12/692

8 Fordwich Road
Welwyn Garden City
Herts
AL8 6EY

I live at 8 Fordwich Road and my neighbours at 6 Fordwich Road have submitted a planning application. These are my comments on that.

**DRAWING TITLE**  
PROPOSED SINGLE STOREY SIDE  
AND REAR EXTENSIONS

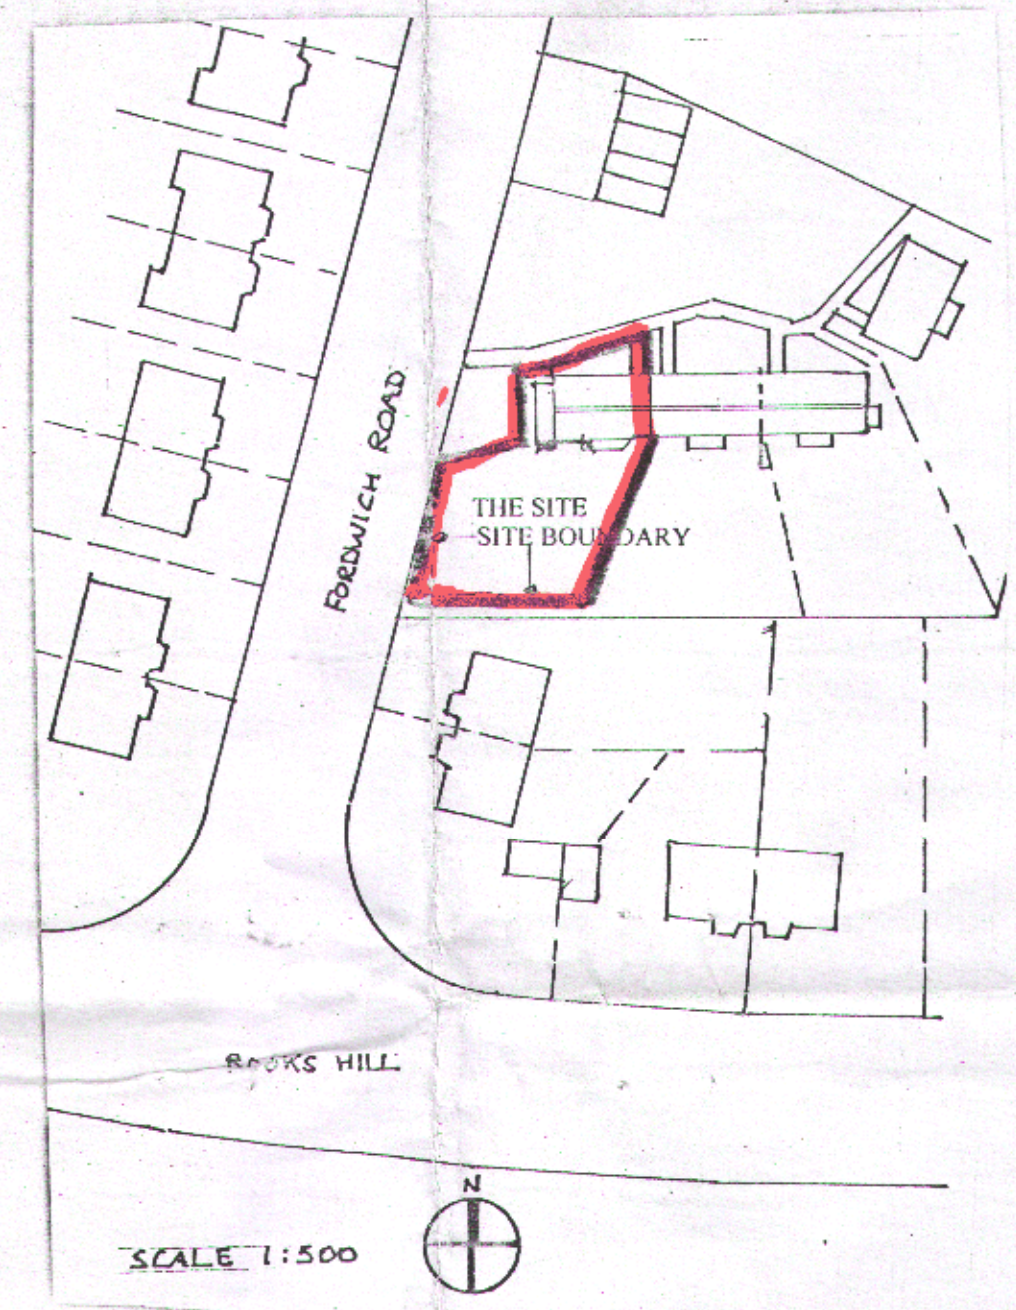
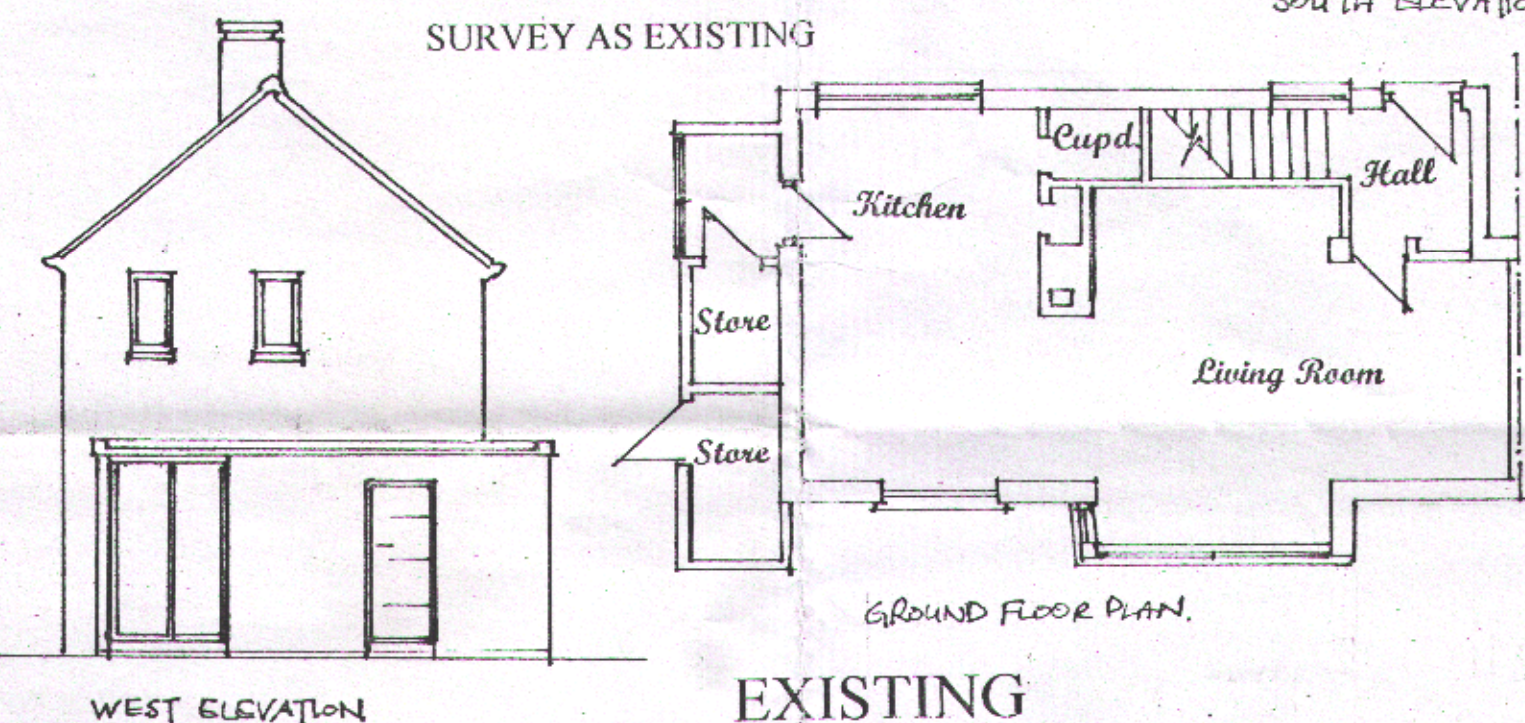
I would say in general that an extra bedroom would mean that parking and security arrangements should be given more thought than they have been offered in these plans. Also, I think a section of the extension is close to the party wall and I would like to give this further consideration. I also need to look again at the arrangements for access and how this would affect the side access point for 6 Fordwich Road, which provides an additional access point to the accommodation.

Any extension to the property should take these into account. Finally the piano playing has in the past disturbed the sleep of the residents of 8 Fordwich Road, and some attention should be given to sound-proofing while there are general works being undertaken to the living room.
